Application No: K/17/22/PL
Site Address: Panorama Golden Acre Kingston BN16 1QP
Description of works: Conversion of existing 2 No flats into 1 No dwelling, single-storey extension with a sloping roof, new porch on ground floor, conservatory at first floor and roof extension, replacement of existing windows, doors and roof tiles. This site is in CIL Zone 4 and is CIL Liable as new dwelling.

Thank you for your internet representation made on 7th July 2022 which has been recorded as no objection with the comments as follows:

Drawing Title: Proposed Second Floor Roof Extension
Planning

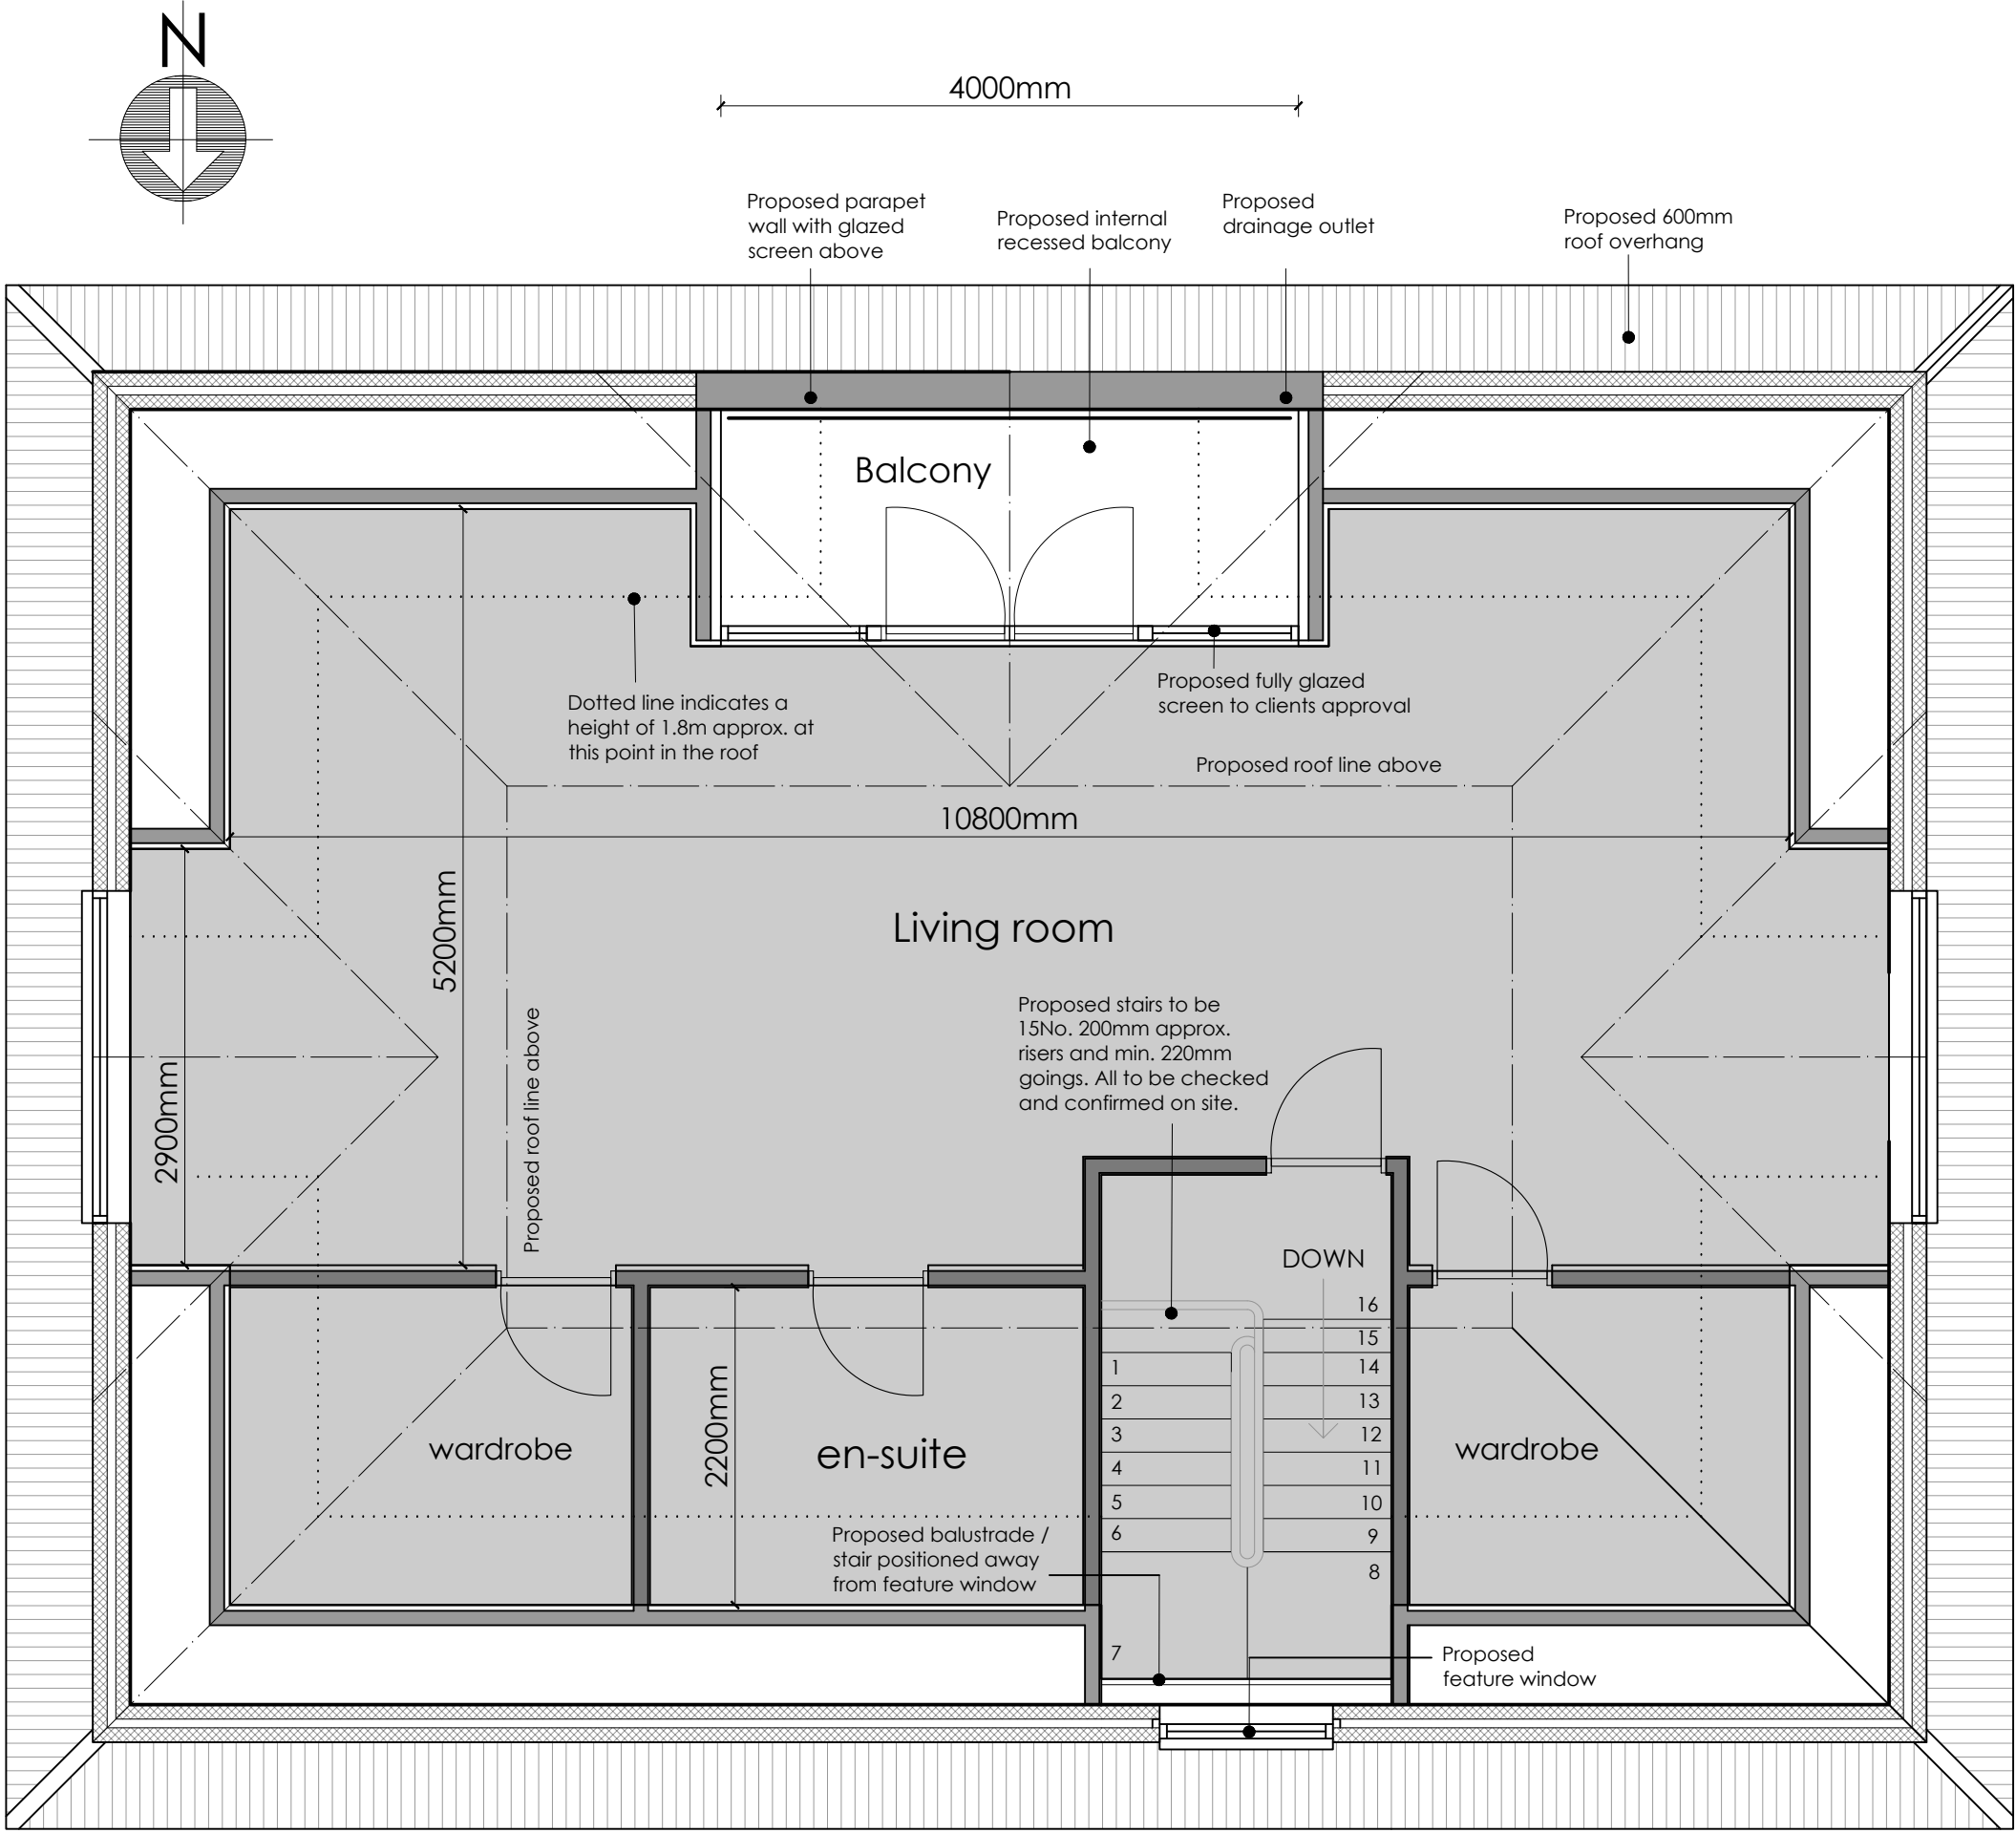
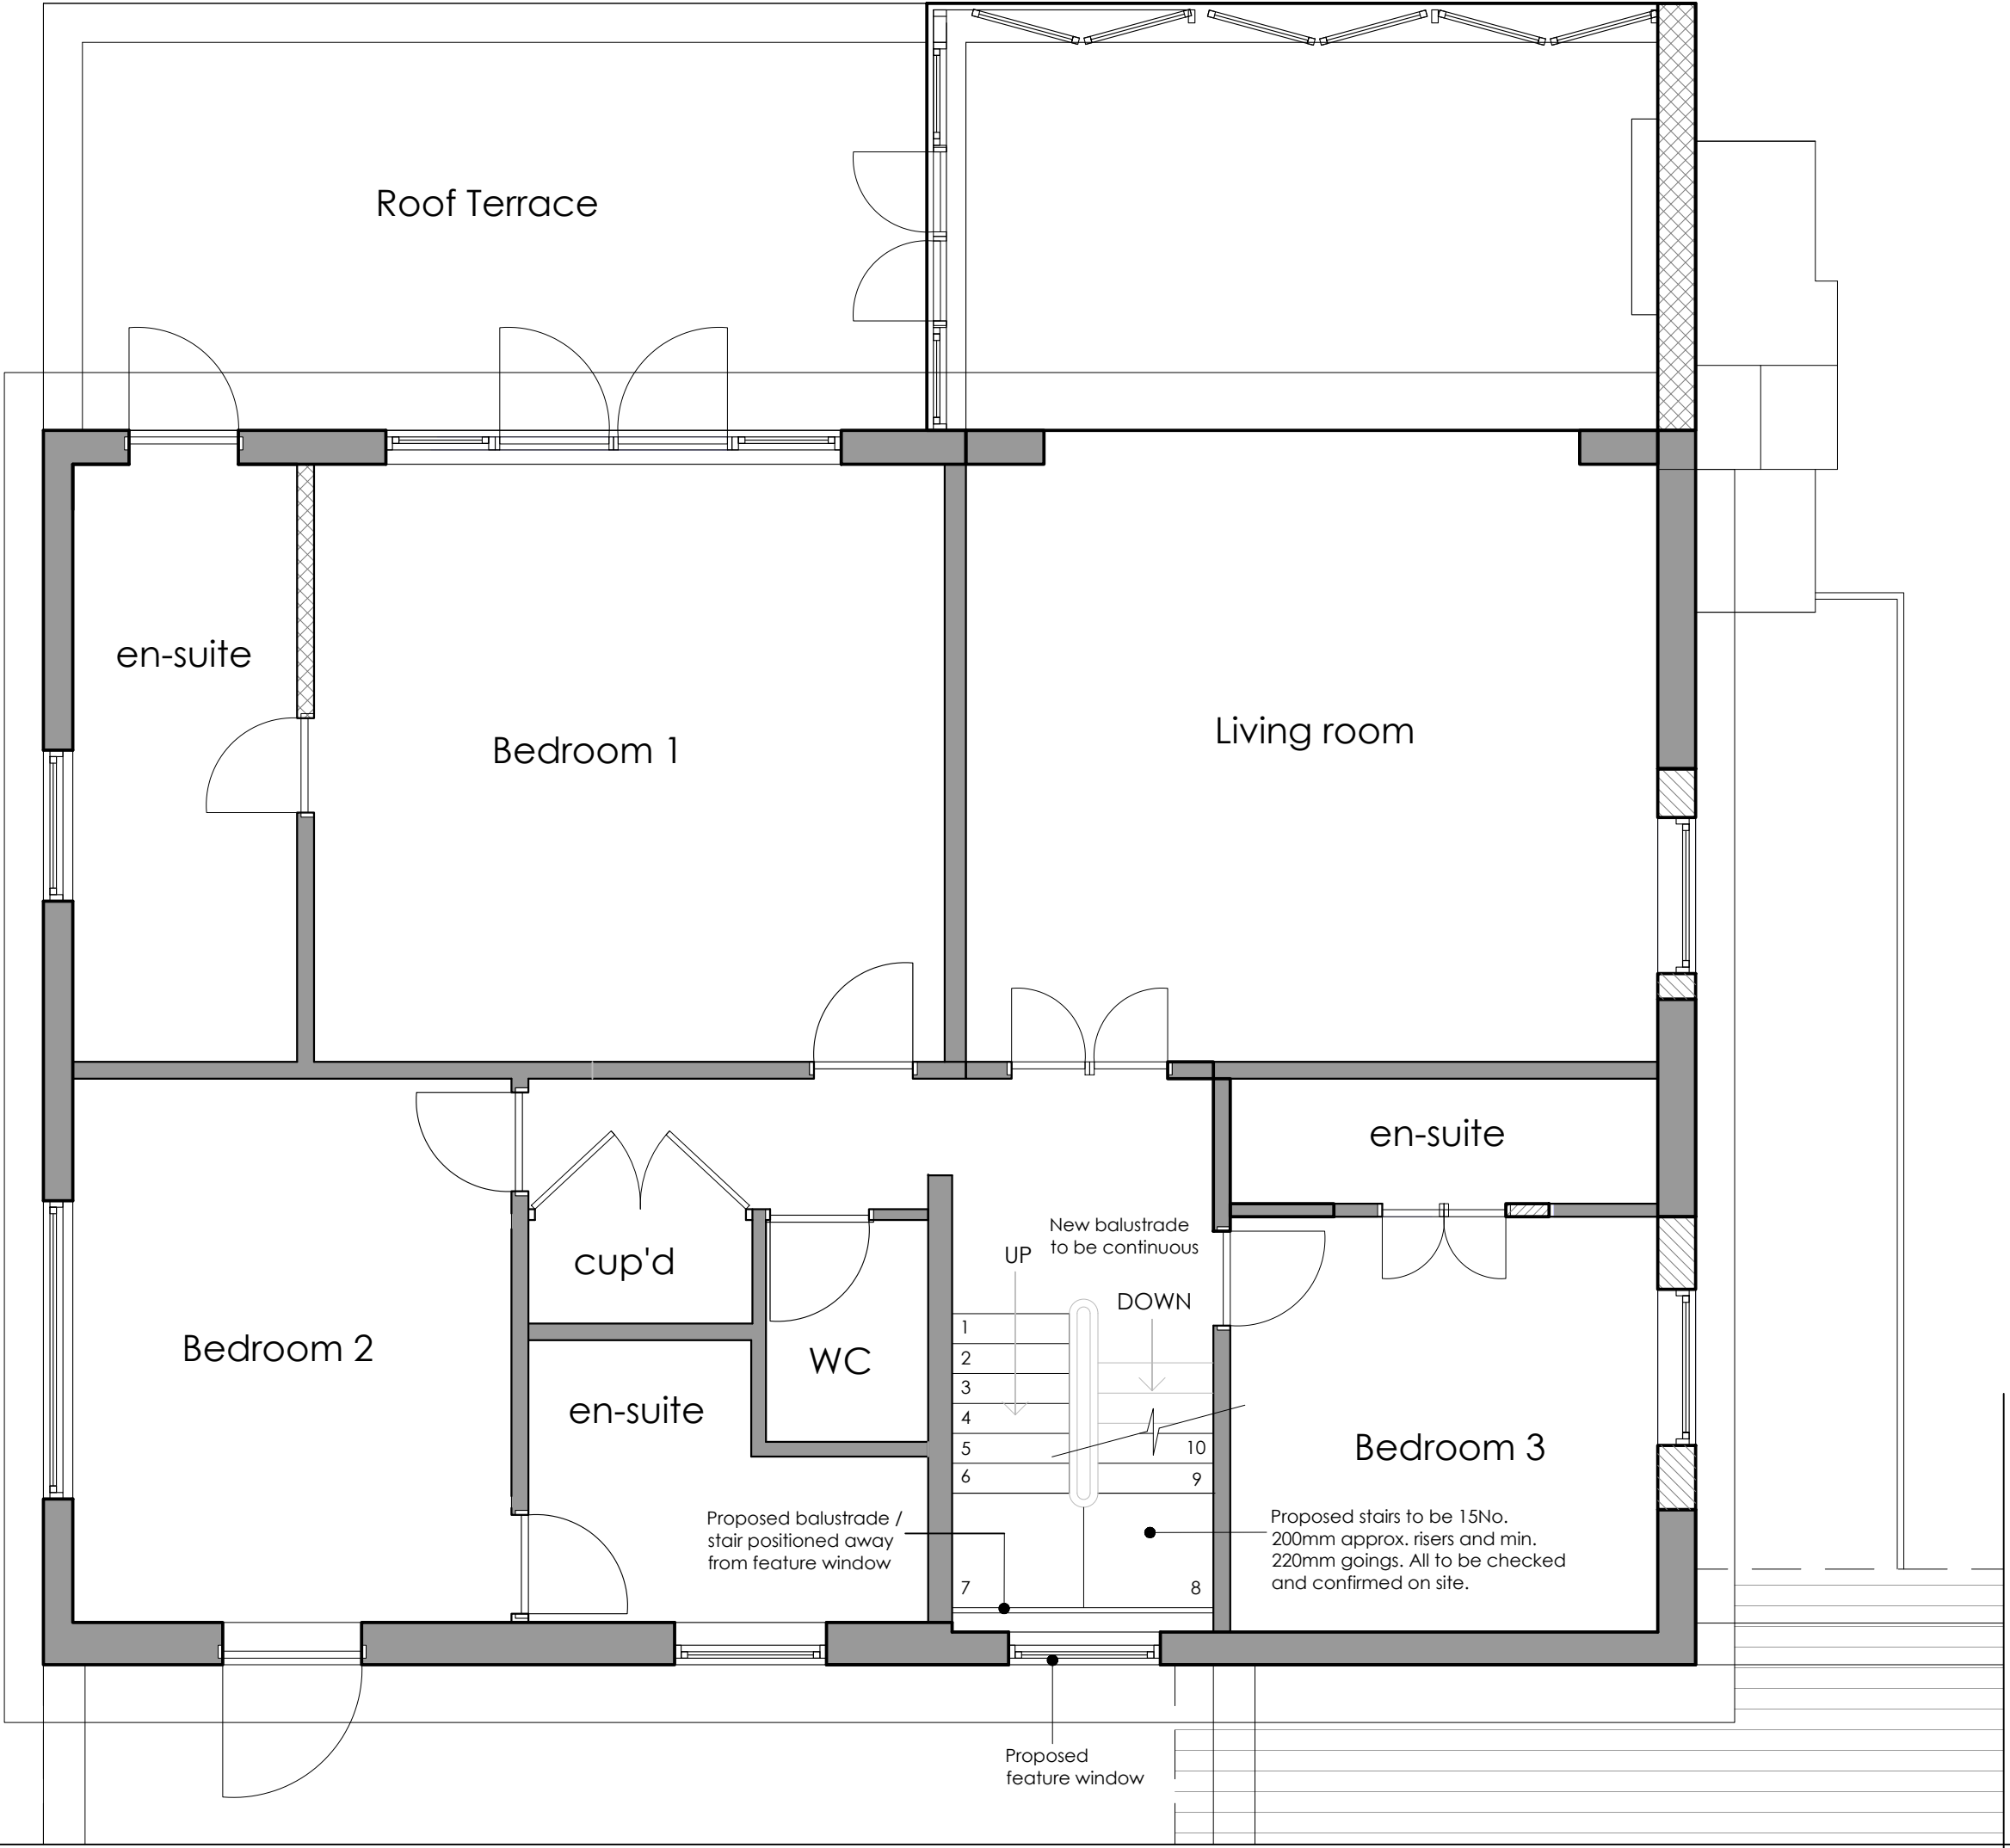
Council has no objection subject to the condition relating to previous application K/40/20/HH I being repeated "Screening shall be constructed at a height of 1.7m from the roof terrace floor level, and extend along the entirety of the Eastern, and 1.5m of the Northern sides of the terrace.", and that the case officer is satisfied that any new windows included in this application do not affect the privacy of neighbouring properties.
